Fosse Green Energy

EN010154

Schedule of Changes

Change Notification

### Statutory and Non-Statutory Features of Historic Environment - Sheet 4 of 6

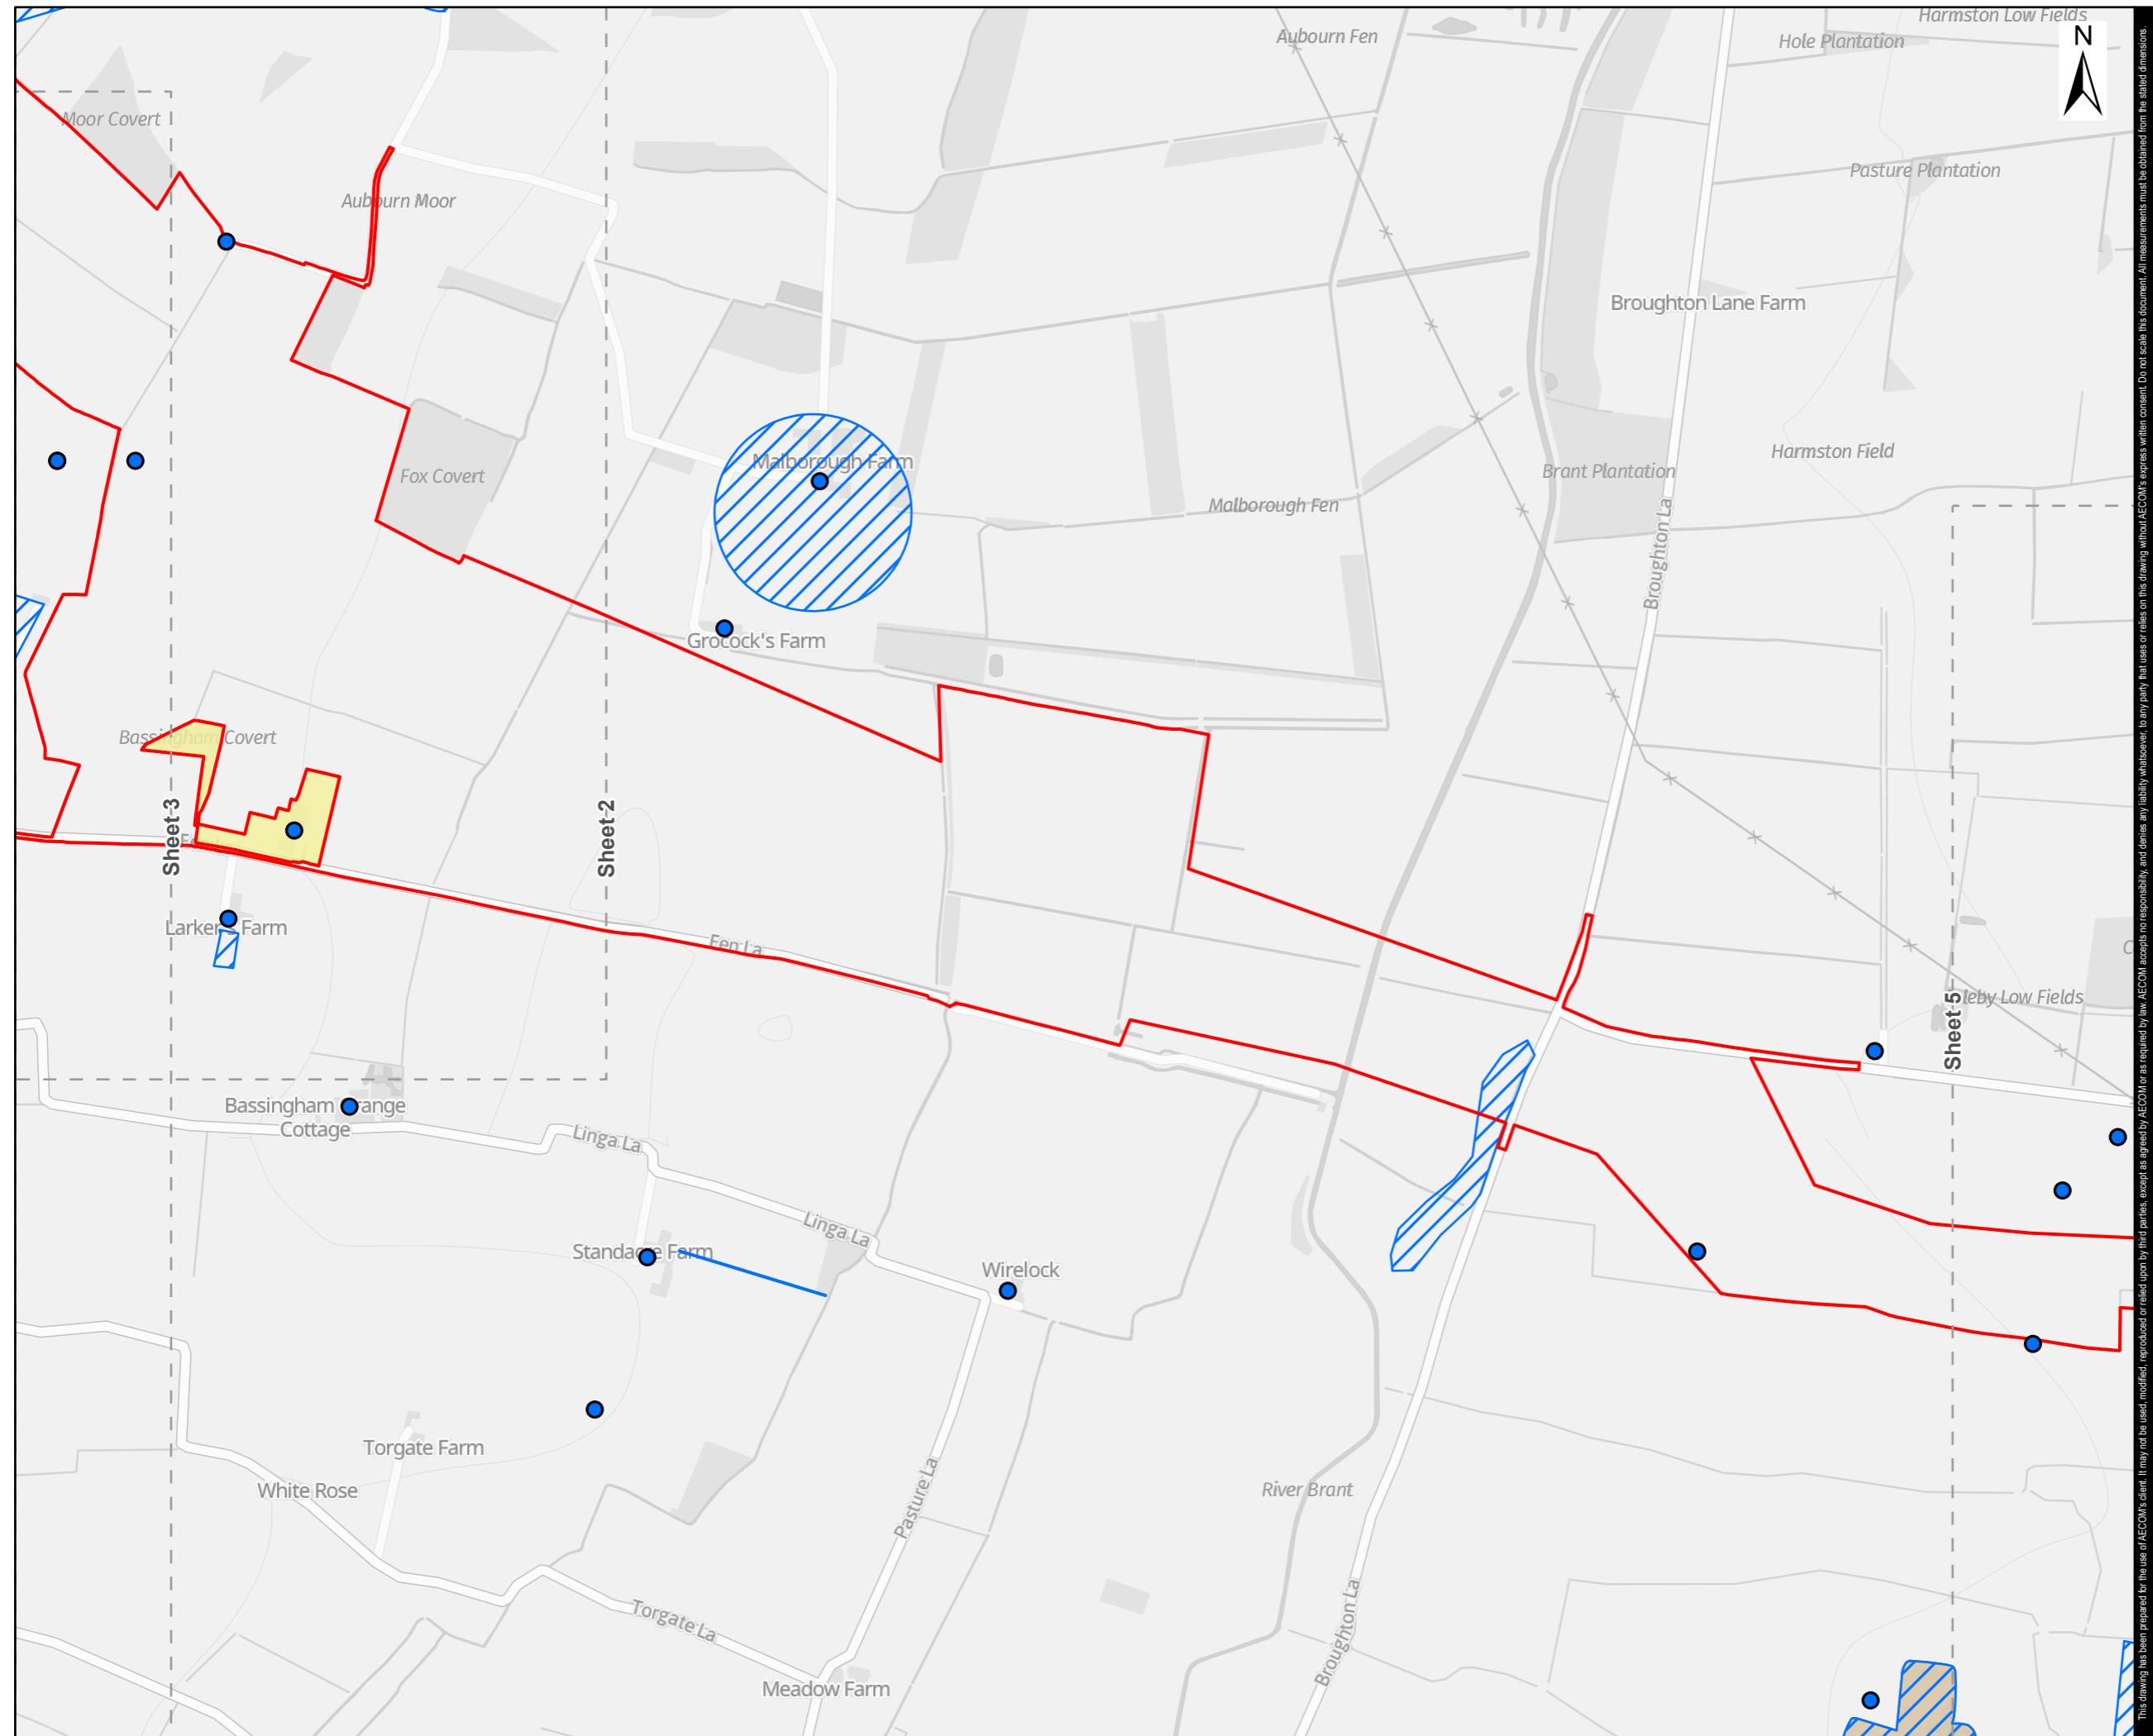
Examination Library Reference	Document Title	Change (Y/N)	Summary of Change	Change Notification Reference
AS-011	2.7 Waterbodies in a River Basin Management Plan	Y	Sheets 1 and 2 of the Waterbodies in a River Basin Management Plan [AS-110] have been updated to show the amended red line boundary which comprises the removal of an area of approximately 13 hectares, to the north of Thurlby.	AS-110 Change Request 1 - 2.7 Waterbodies in a River Basin Management Plan (Revision 3)
AS-012	2.8 Statutory or Non-Statutory Sites or Features of the Historic Environment Plan	Y	The key plan and sheets 2 and 3 of the Statutory or Non-Statutory Sites or Features of the Historic Environment Plan [AS-111] have been updated to show the amended red line boundary which comprises the removal of an area of approximately 13 hectares, to the north of Thurlby	AS-111 Change Request 1 - 2.8 Statutory or Non Statutory Sites or Features of the Historic Environment Plan (Revision 3)
